High Hoyland Parish Meeting
c/o Dr. Lucinda Perigo
Twin Trees
Bank End Lane
High Hoyland
Barnsley
S75 4BB
Mbl: 07549 444316

Planning Application: 2025/0955

Site Address: Land West of Norfield House, Bank End Lane, High Hoyland

Proposal: Erection of Detached Dwelling (Self/Custom Build)

STREET SCENE SHOWING RELATIONSHIP WITH ADJACENT PROPERTIES VIEWED FROM BANK END LANE. SCALE 1:200 @ a1

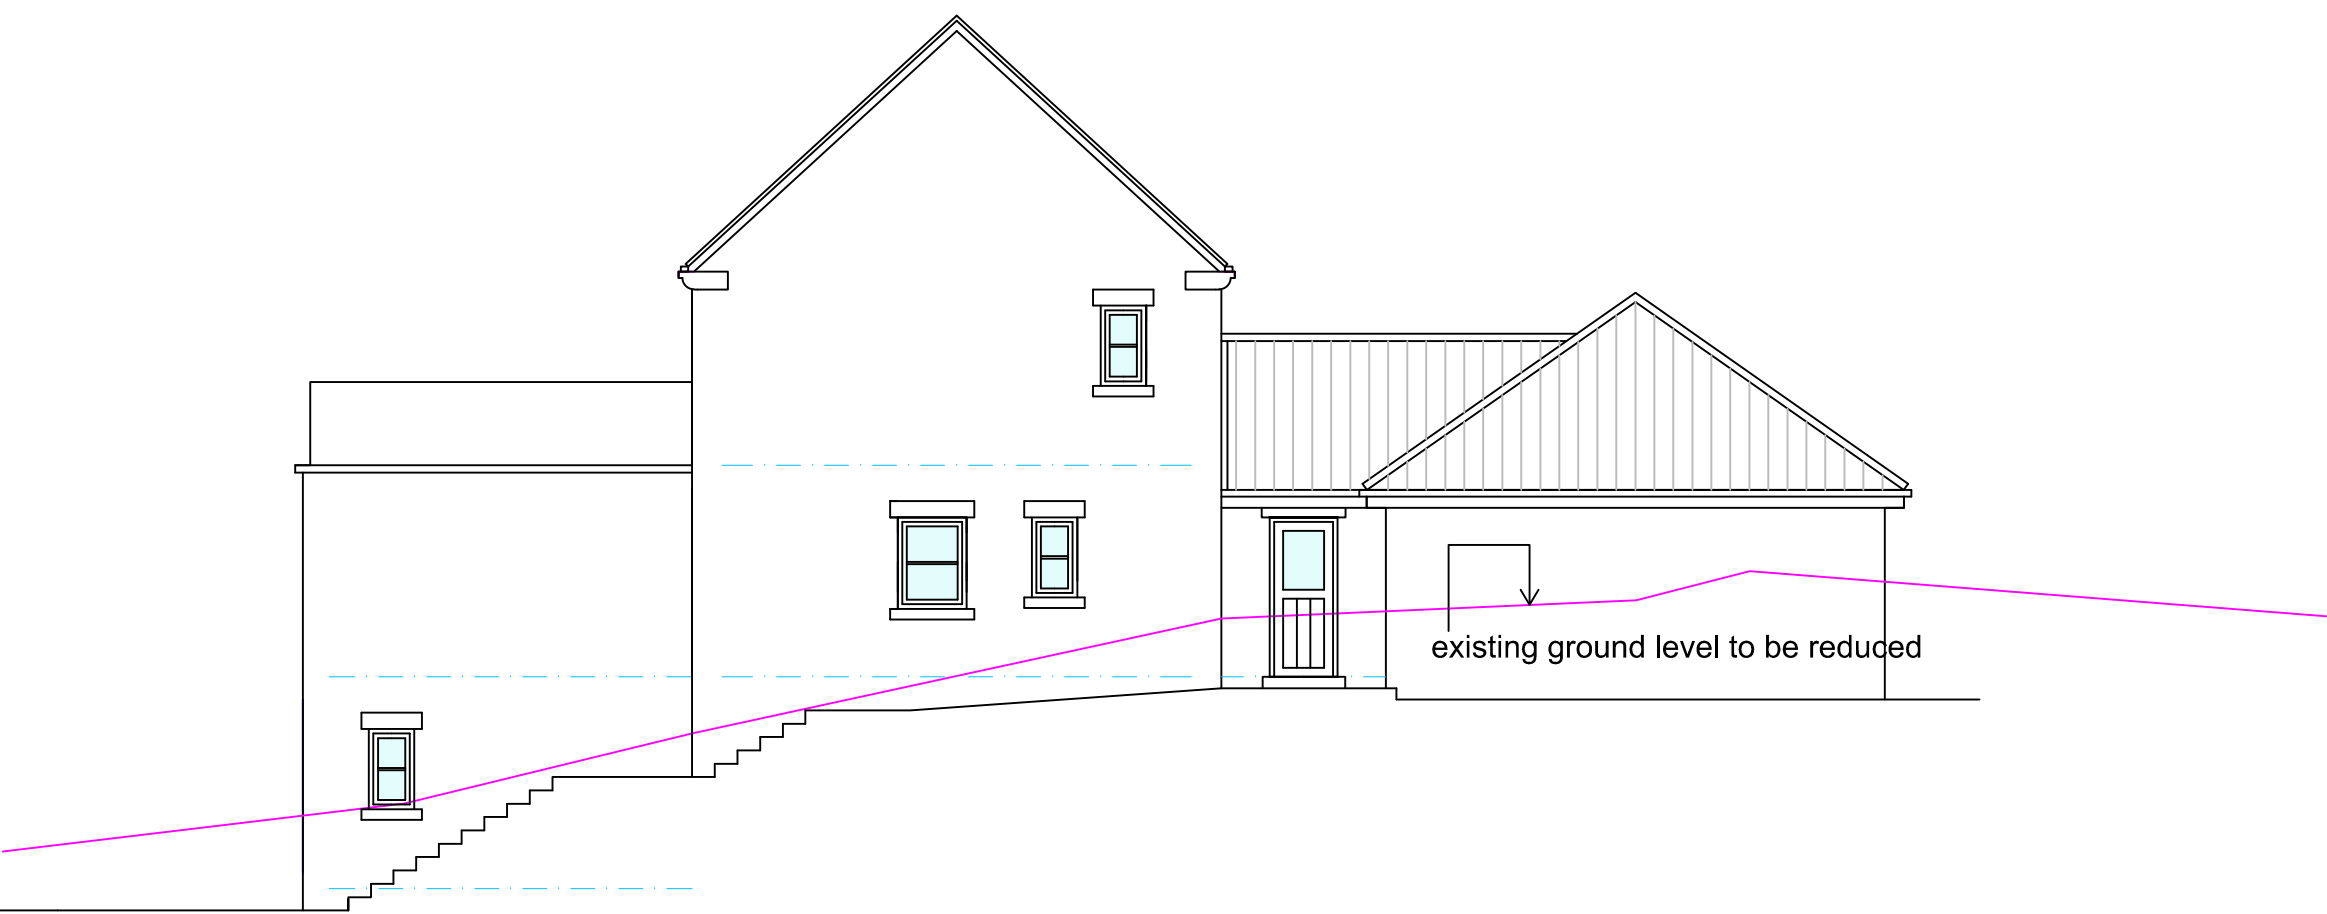
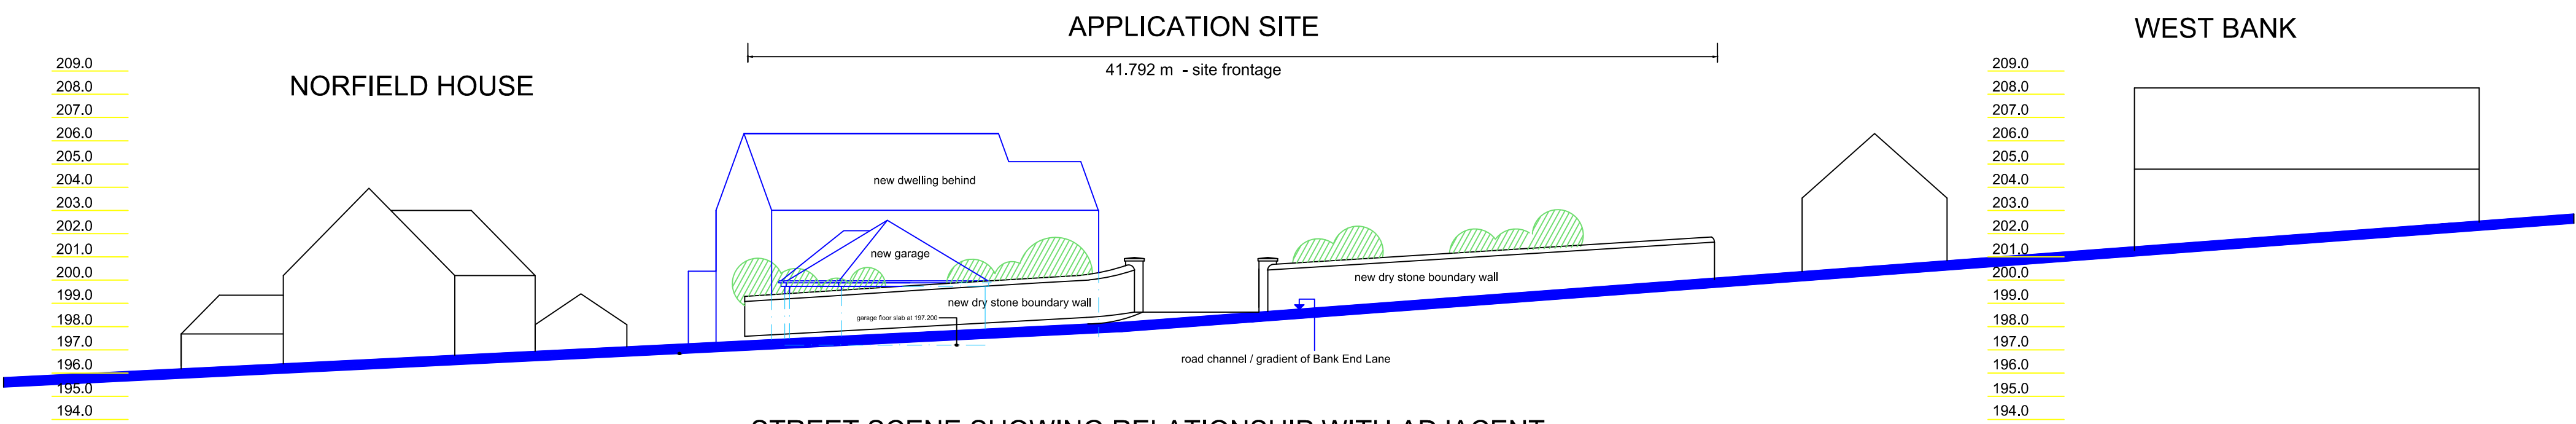
The Planning Statement describes the proposal as a “two-storey” dwelling when viewed from Bank End Lane, with a lower-ground “entertainment suite” to the rear, resulting in three fully expressed storeys facing the valley.

In reality, the combined effect of:

- Three storeys of accommodation to the rear;
- A large footprint extending deep into the plot;
- A detached double garage and extensive hardstanding;

is that the building is substantially larger and more voluminous than neighbouring properties. Street-scene drawings and elevation plans show a dwelling that:
